Application for removal or variation of a condition following grant of
planning permission. Town and Country Planning Act 1990.
Planning (Listed Buildings and Conservation Areas) Act 1990

Retention of 4 bedroom bungalow to the rear of 207 Blaby Road, Enderby (Revised Scheme of 18/1188/FUL) | 207 Blaby Road Enderby Leicestershire LE19 2AR

19/0556/FUL

2,6

ROOF PLAN

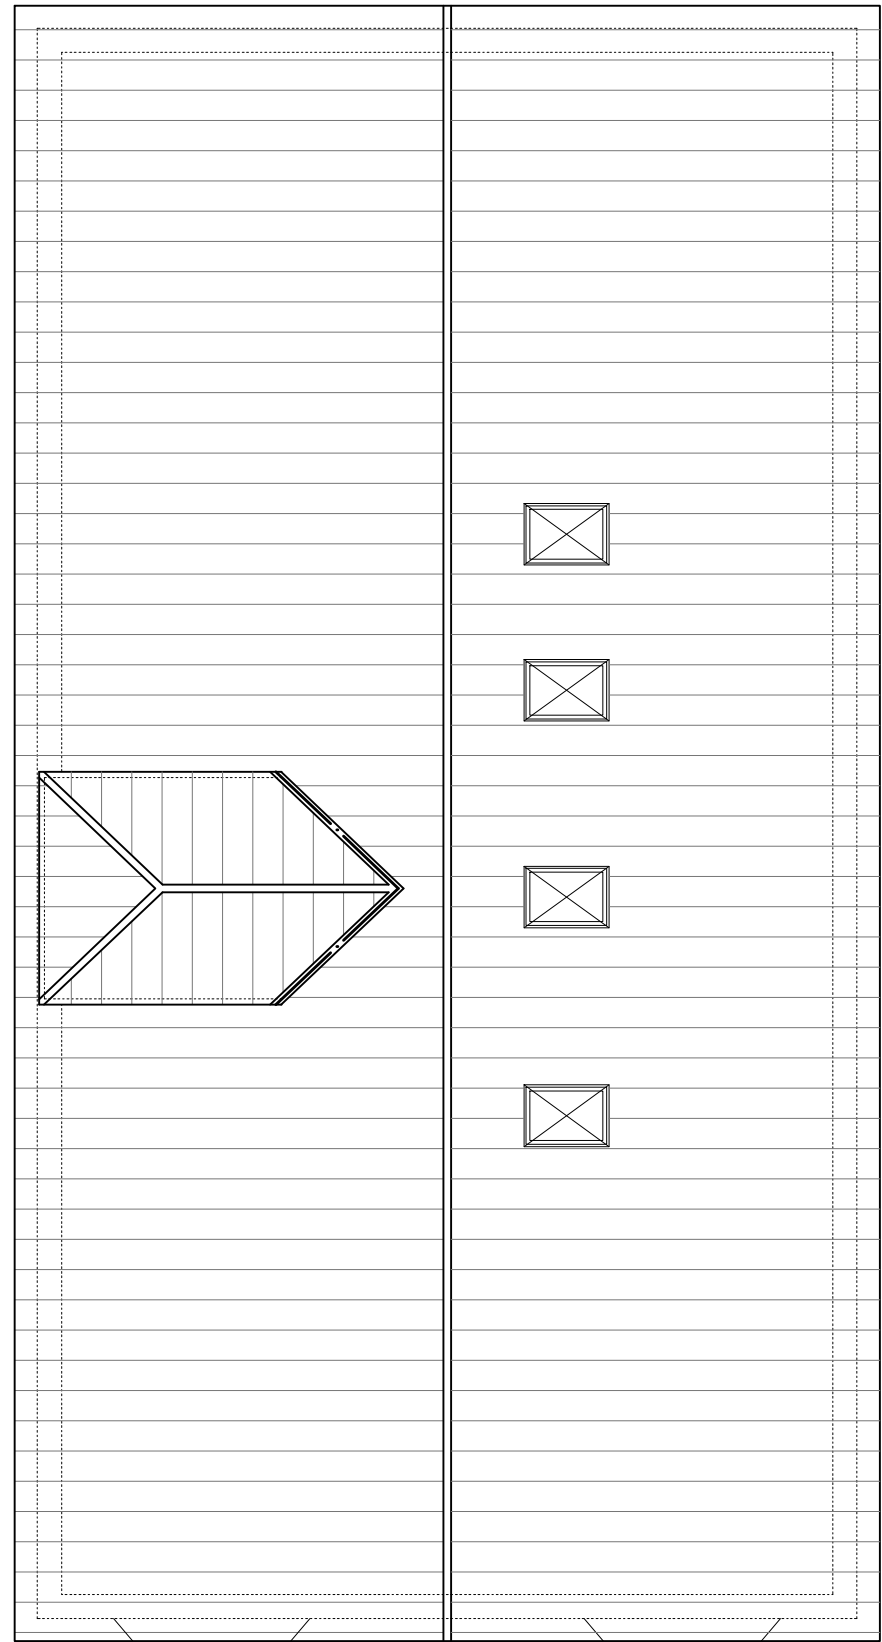
Condition 6 - In relation to roof Velux windows on the western slope only. The first floor window serving bedroom 4 shall be obscurely glazed and shall remain so in perpetuity. The four roof Velux windows on the western slope are to change to clear glass as the window-sill is 2m from the floor.

PROPOSED SITE
1:500

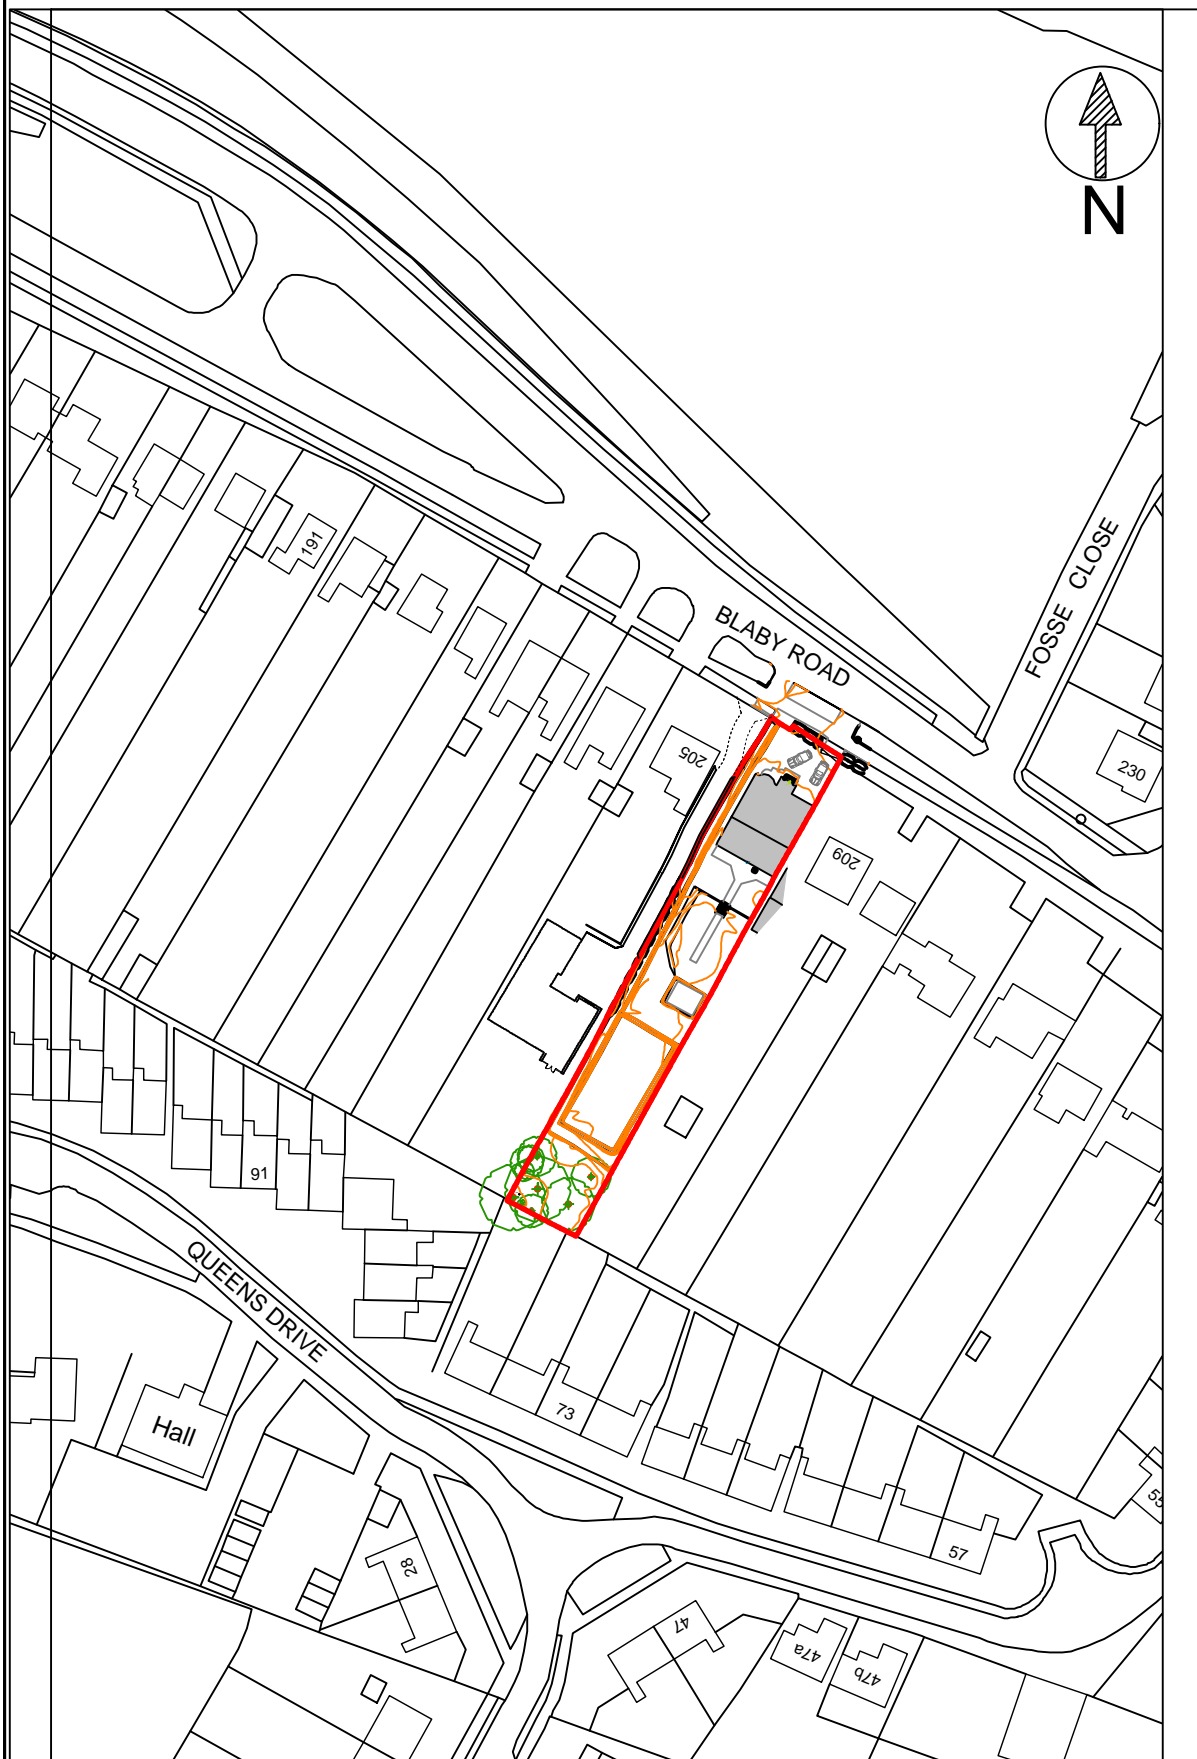
Condition 2 (Materials) - Driveway to change from tarmac to gravel finish to match existing driveway of 205a Blaby Bungalow.
